August 3, 2023

**Re: Maverik- Albuquerque**  
**2121 Yale Blvd. SE**  
**Traffic Circulation Layout**  
Engineer's/Architect's Stamp XX-XX-XX (M15-D021D)

Based upon the information provided in your submittal received 07-26-23, the above referenced plan cannot be approved for Building Permit until the following comments are addressed:

MAVERIK STORE  
2121 YALE BLVD SE  
ALBUQUERQUE, NEW MEXICO  
TRAFFIC CIRCULATION LAYOUT PLAN

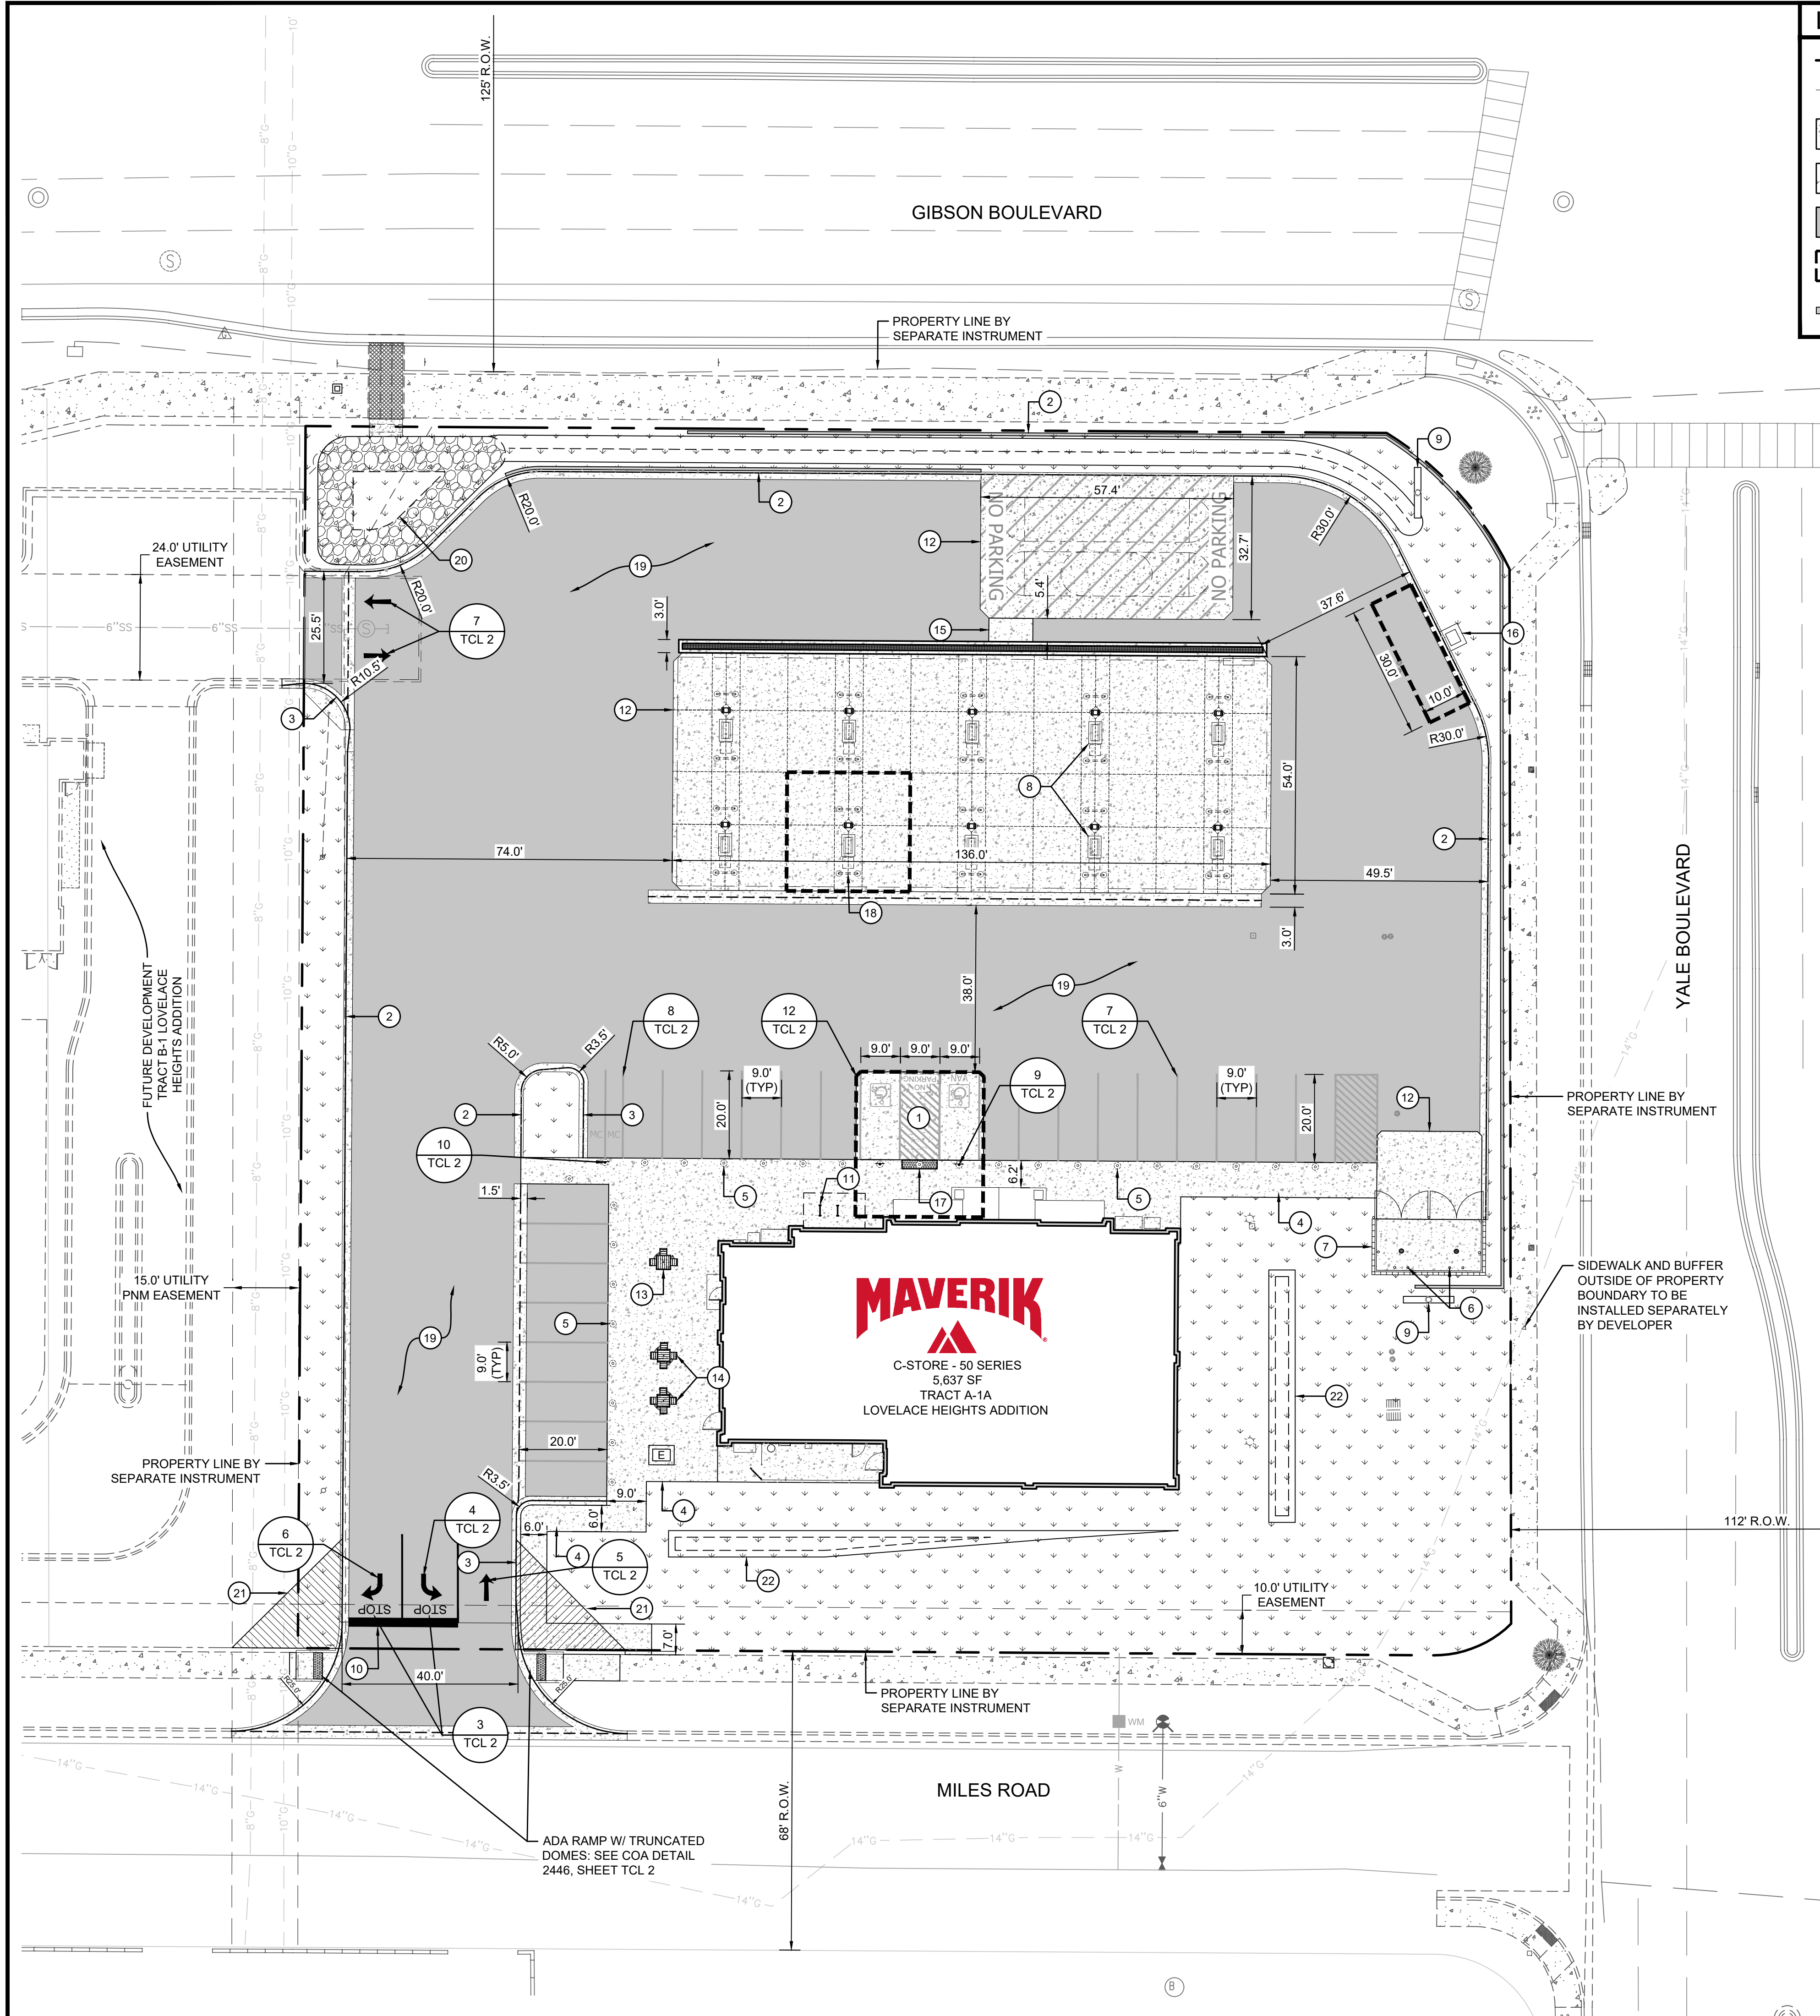
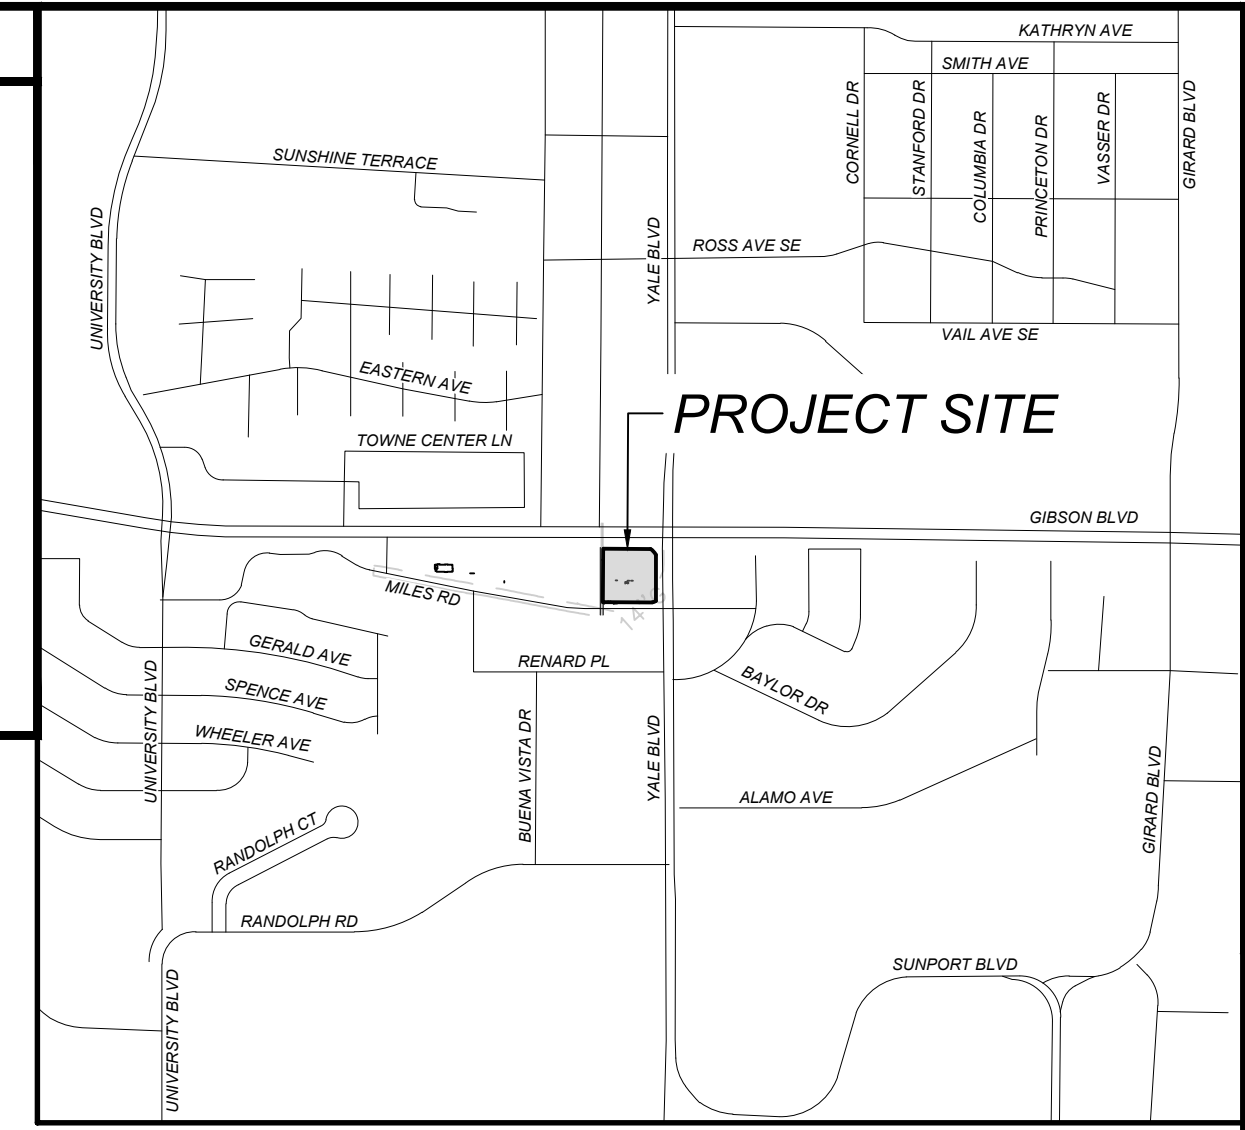
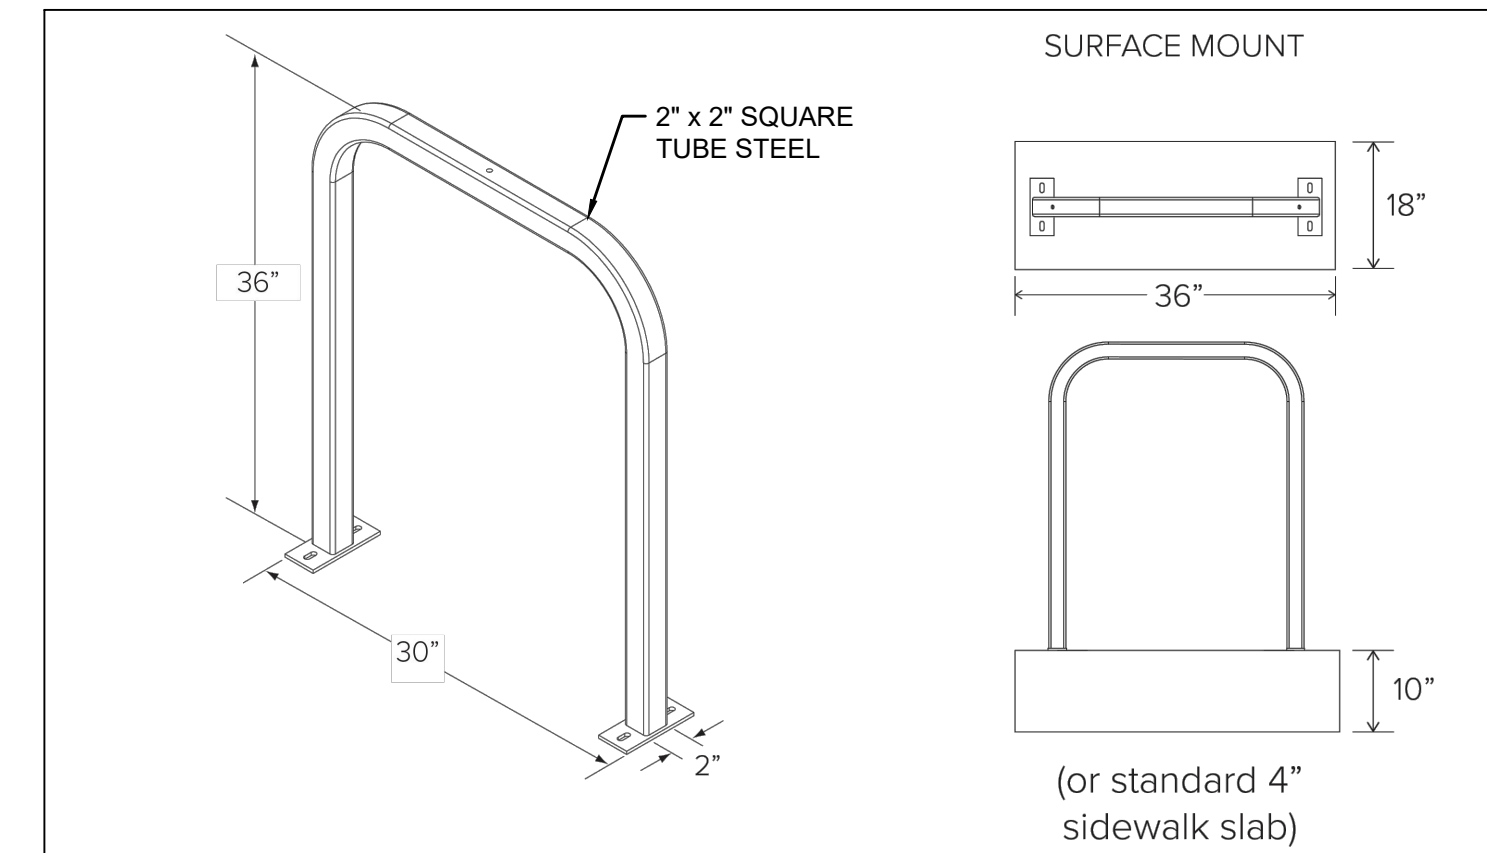
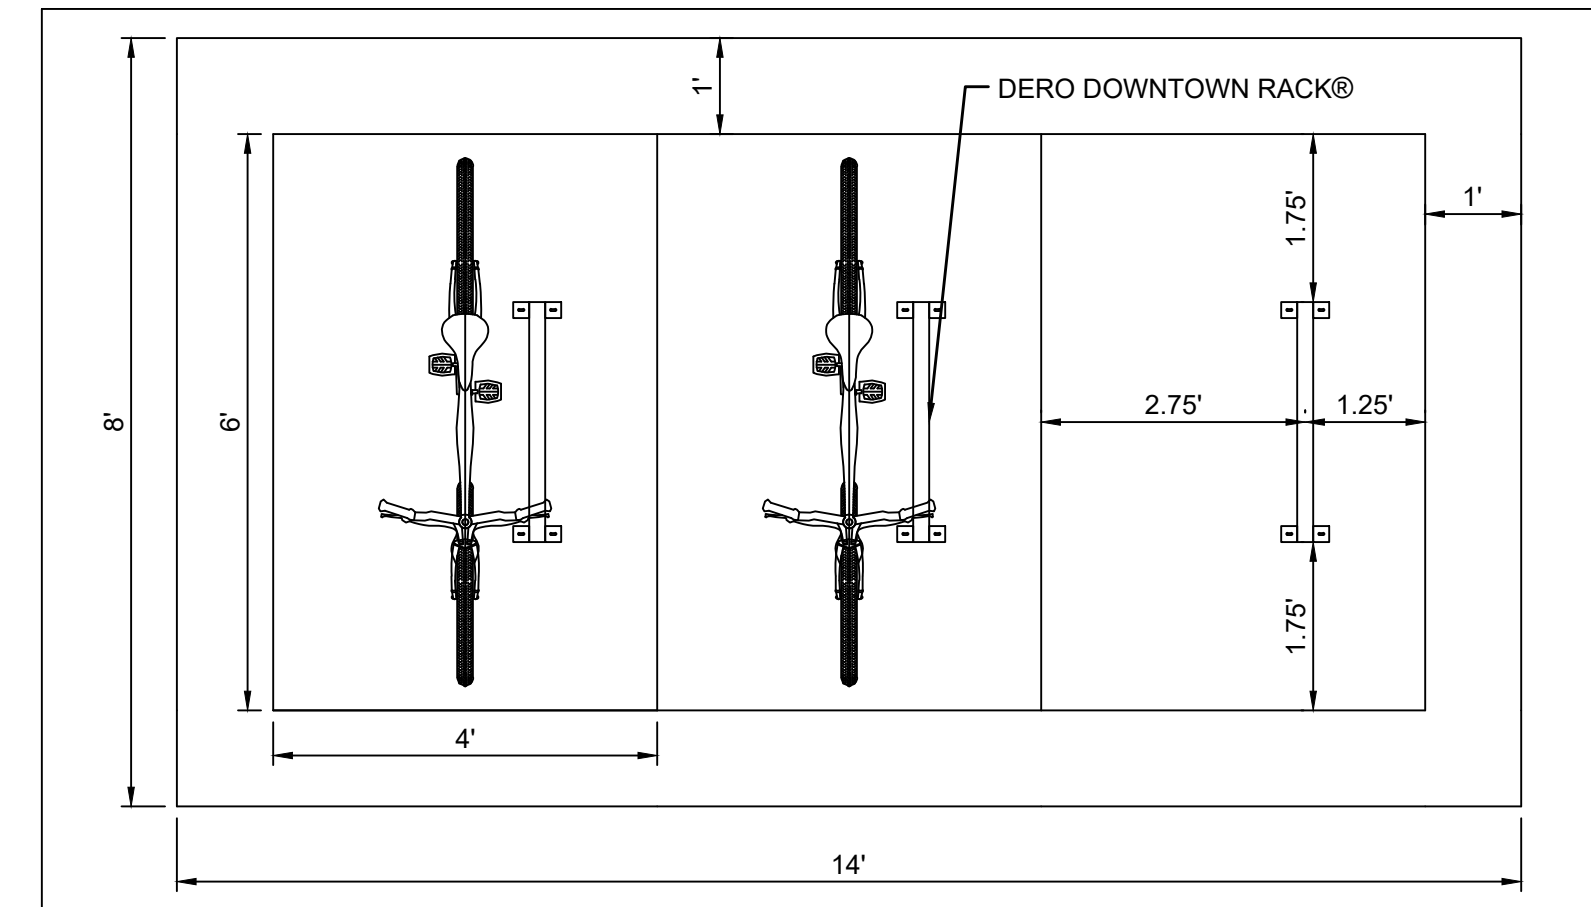
1. List the number of Motorcycle parking spaces required by the IDO.
2. The traffic circulation layout must be stamped, signed, and dated by an engineer or architect licensed in the state of New Mexico.

3. Identify all existing access easements and rights of way width dimensions.
4. Identify the right of way width, medians, curb cuts, and street widths on Gibson Blvd., Yale Blvd. and Miles Rd.

5. A minimum 5 ft. Wide sidewalk and 5 ft. wide buffer is required to be developed from property line to property line along Miles Rd. please show dimensions and details on the site plan, and reference COA std dwg 2430.

6. Please clarify: are you going to develop a sidewalk and buffer along Gibson Blvd. and Yale Blvd.? If so, please provide details and reference COA std dwg.

7. Site access off Miles: Show on the site plan the site access details and radii.
8. The ADA accessible parking sign must have the required language per 66-7-352.4C NMSA 1978 **"Violators Are Subject to a Fine and/or Towing."** Please call out detail and location of signs.

9. ADA curb ramps must be updated to current standards and have truncated domes installed.
10. Motorcycle parking spaces shall be designated by its own conspicuously posted upright sign, either free-standing or wall mounted per the zoning code.

11. The pavement marking "MC" should be shown in the opposite direction for motorcycles entering the parking space.
12. All bicycle racks shall be designed according to the following guidelines:

- 16. Per the IDO, a 6 ft. wide ADA accessible pedestrian pathway is required from the public sidewalk to the building entrances. Please clearly show this pathway and provide details.

- 17. Per DPM, a 6 ft. wide ADA accessible pedestrian pathway is required from the ADA parking stall access aisles to the building entrances. Please clearly show this pathway and provide details.

- 18. ADA accessible pedestrian pathway should not be placed behind parking space or adjacent to a vehicular way. Vehicle and pedestrian/wheel chair conflicts should be avoided as much as possible.

- 19. Refuse vehicle maneuvering shall be contained on-site. The refuse vehicle shall not back into the public right of way.; provide a copy of refuse approval.

- 23. Work within the public right of way requires a work order with DRC approved plans.
  - 24. Please add a note on the plan stating "All improvements located in the Right of Way must be included on the work order."

- 25. Unused curb cuts must be replaced with sidewalk and curb & gutter. A build note must be provided referring to the appropriate City Standard drawing.
